Application Ref:	3/2025/0385			 <div>Ribble Valley Borough Council</div> <hr/> www.ribblevalley.gov.uk
Date Inspected:	12/08/25	Site Notice:	12/08/25	
Officer:	LW			
DELEGATED ITEM FILE REPORT:				APPROVAL

Development Description:	Proposed single storey extension to rear and side.
Site Address/Location:	Mirfield, 87 Ribchester Road, Clayton le Dale, BB1 9HT.

drawing title
Existing Block Plan
Proposed Block Plan

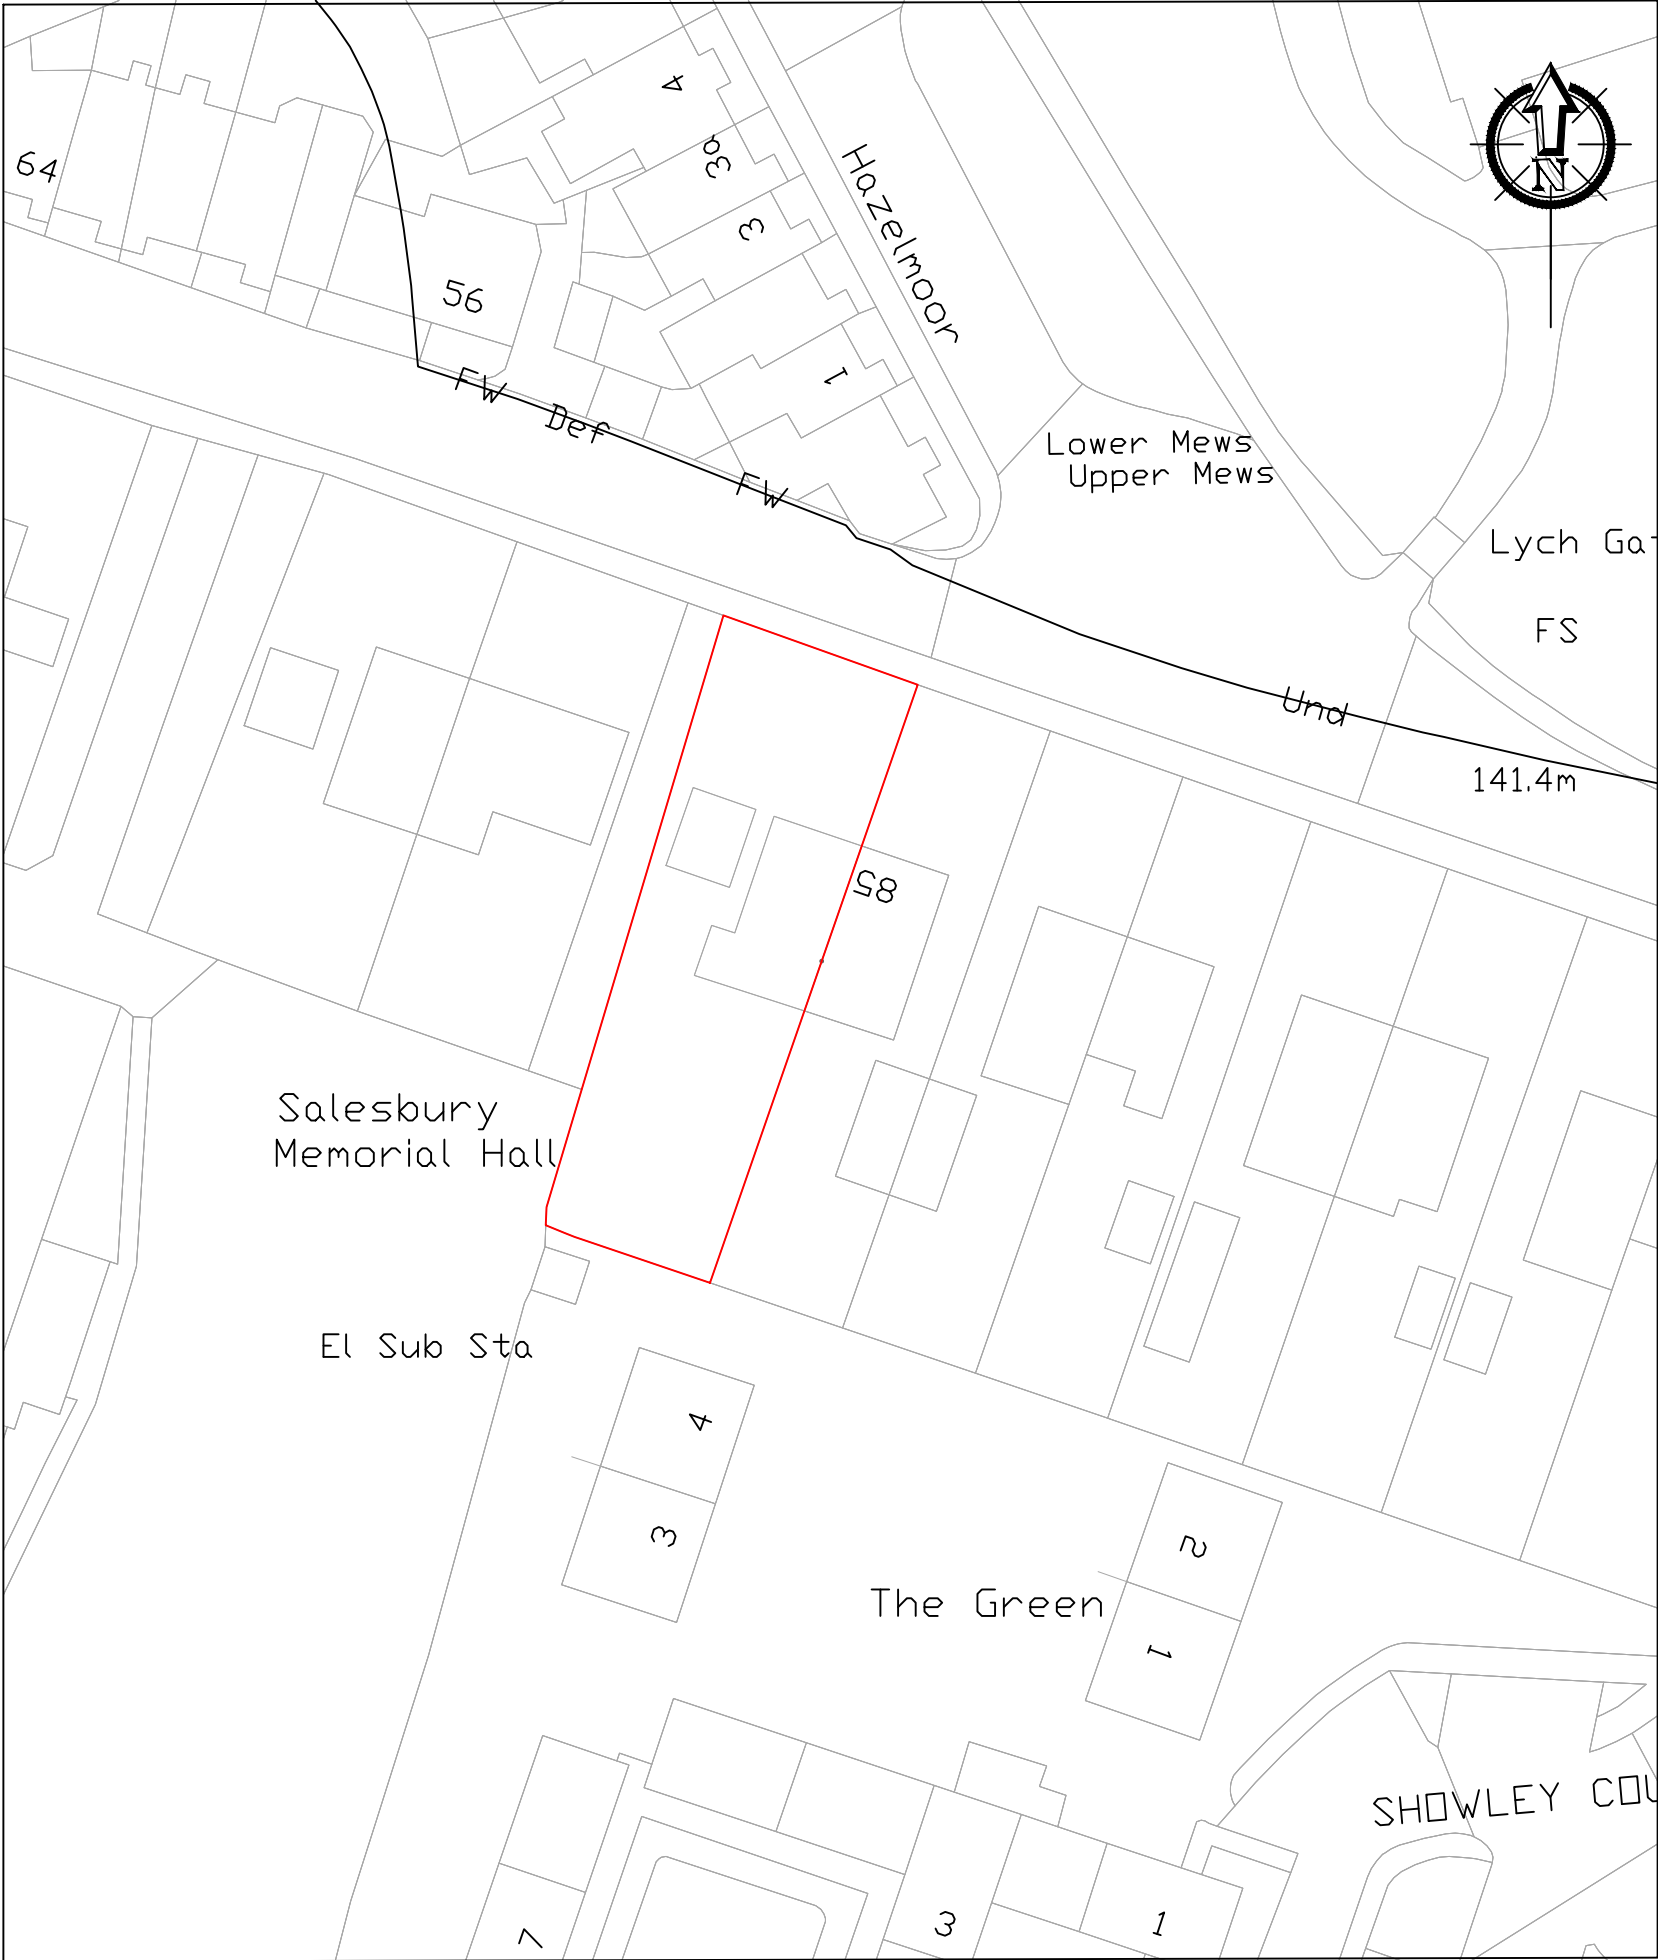
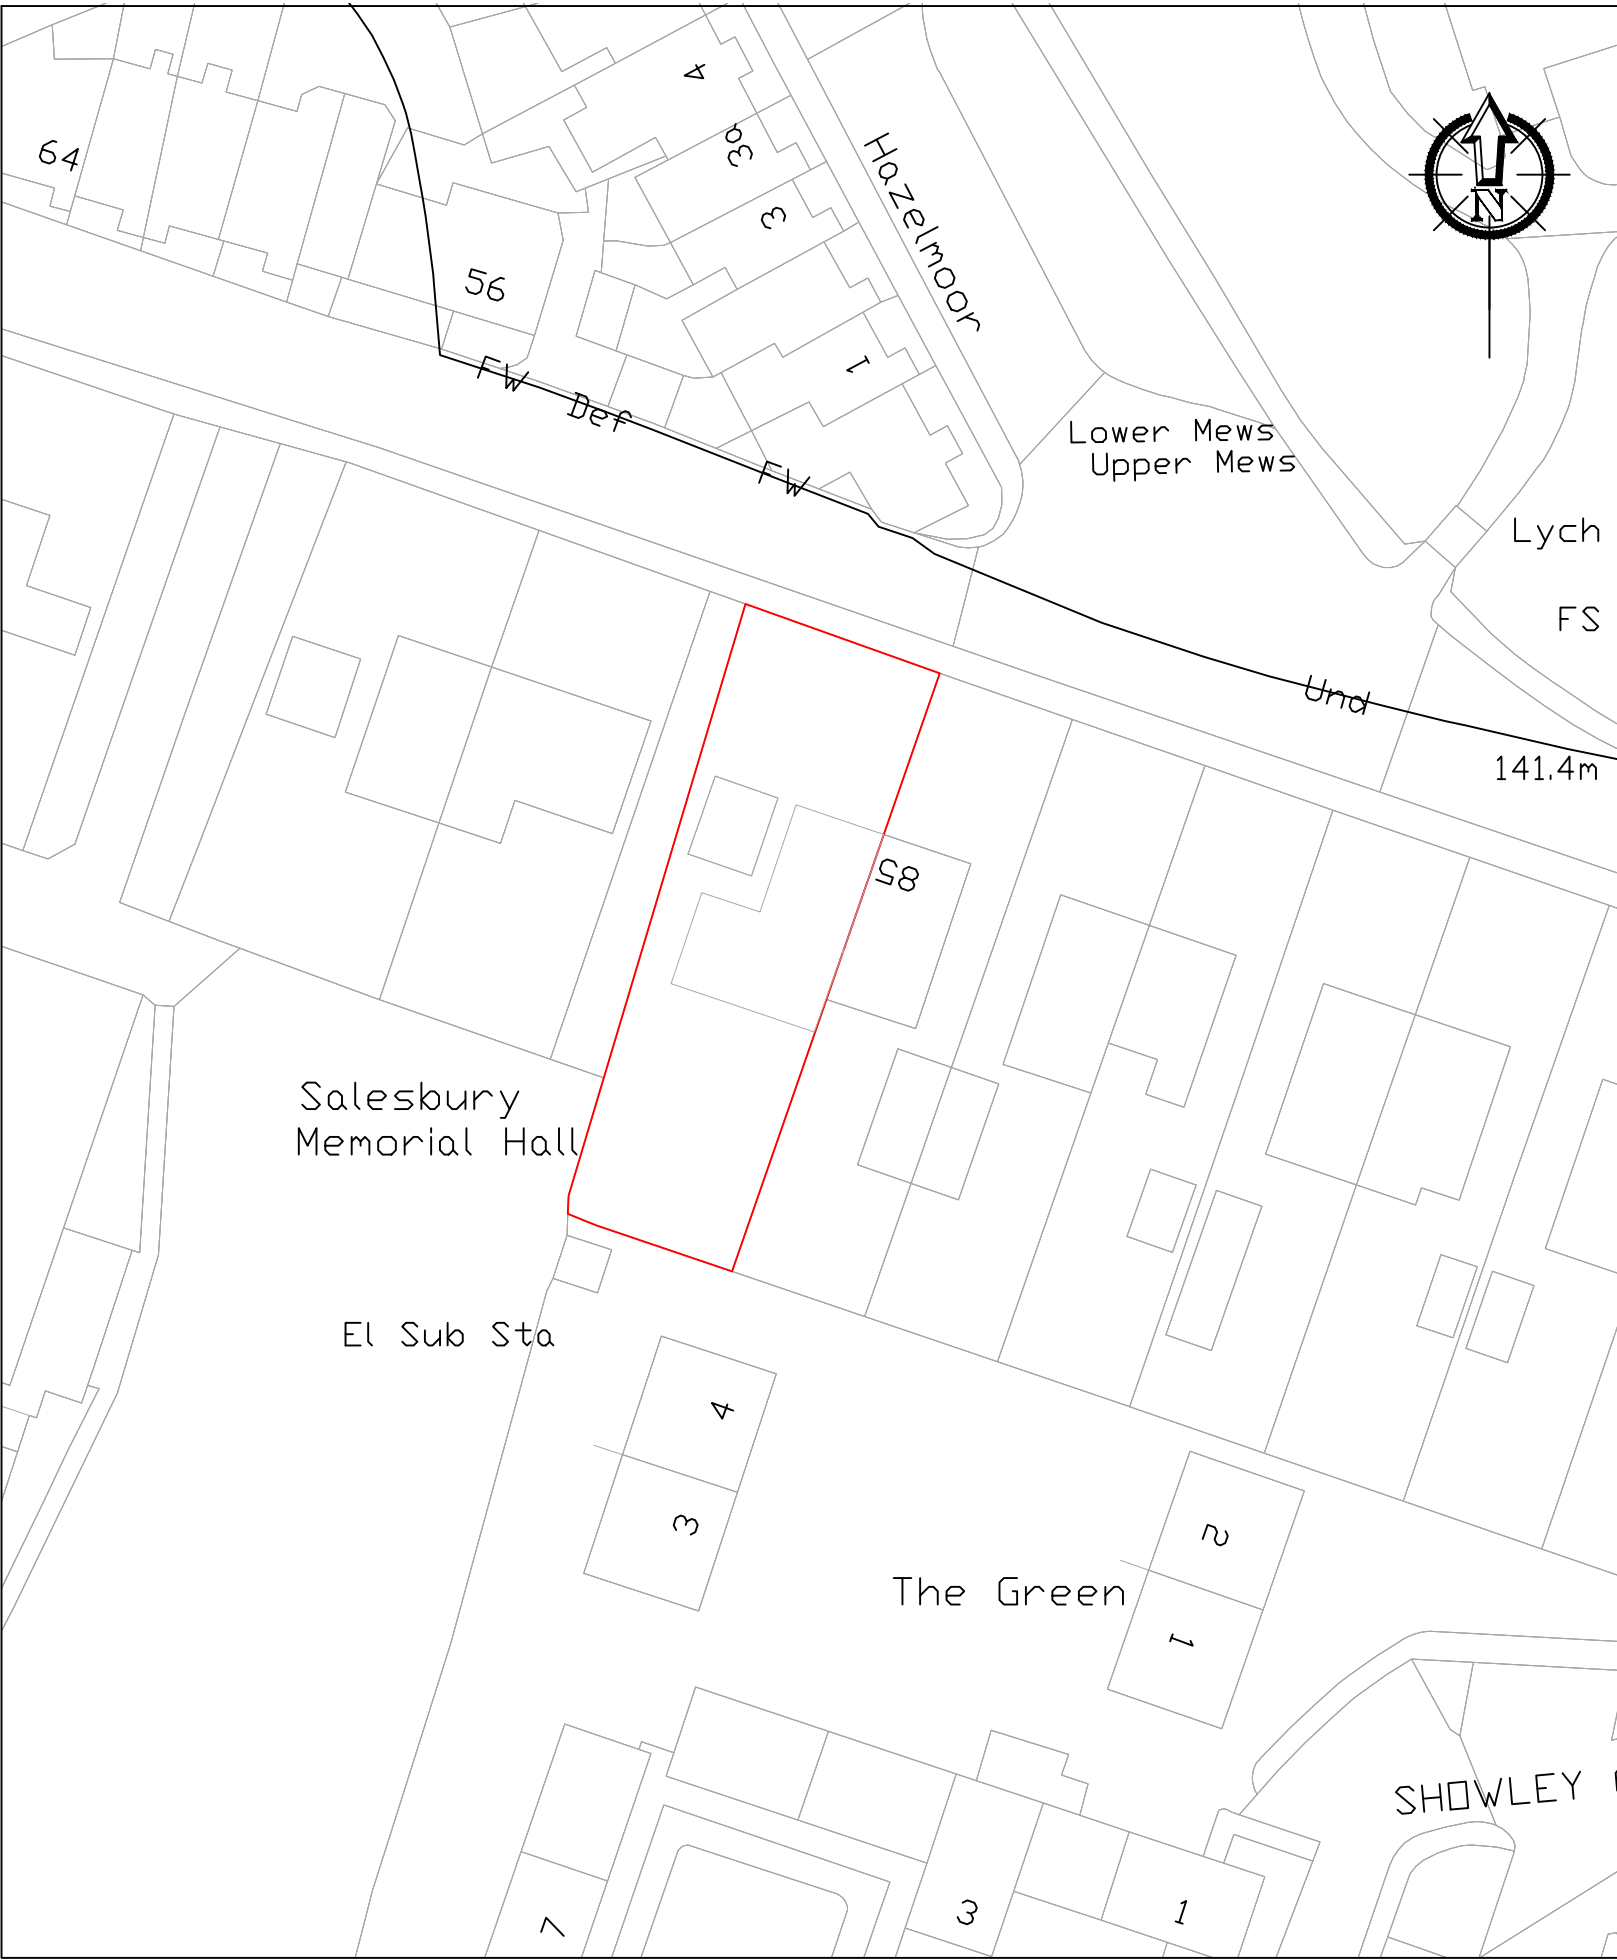
CONSULTATIONS:	Additional Representations.
<p>One letter of objection has been received. The concerns raised within the letter can be summarised as below:</p> <ul style="list-style-type: none"> • The submitted drawings incorrectly show the existing extension featured to the rear of no.85 Ribchester Road to lie on the boundary line; • Loss of light to neighbouring kitchen and dining room windows and garden; • Overdevelopment and overbearing impact due to the scale and massing of the proposal. <p>The above-mentioned concern with regards to submitted drawings is noted; however, as this involves a relatively minor error which does not materially impact the development or prevent a full assessment of the proposal, amended plans have not been sought in this particular instance.</p>

It is noted that concerns have been raised with regards to the loss of light and overbearing impact as a result of the rearward projection of the extension. However, the proposed extension would project 2.7m from the rear elevation of the existing single storey extension featured to the rear of No.85 Ribchester Road. In addition to this, the proposed development would be sited to the west of this neighbouring property and therefore any resultant loss of light would be limited to the later hours of the day. In this context, it is not considered that the proposal would result in any significant detrimental impact upon the occupiers of no.85 Ribchester Road by way of overshadowing, loss of outlook or daylight that would warrant the refusal to grant planning permission in this particular instance. Furthermore, the proposal would remain approximately 6m from No.89 Ribchester Road and therefore no significant undue harm is anticipated in this respect.
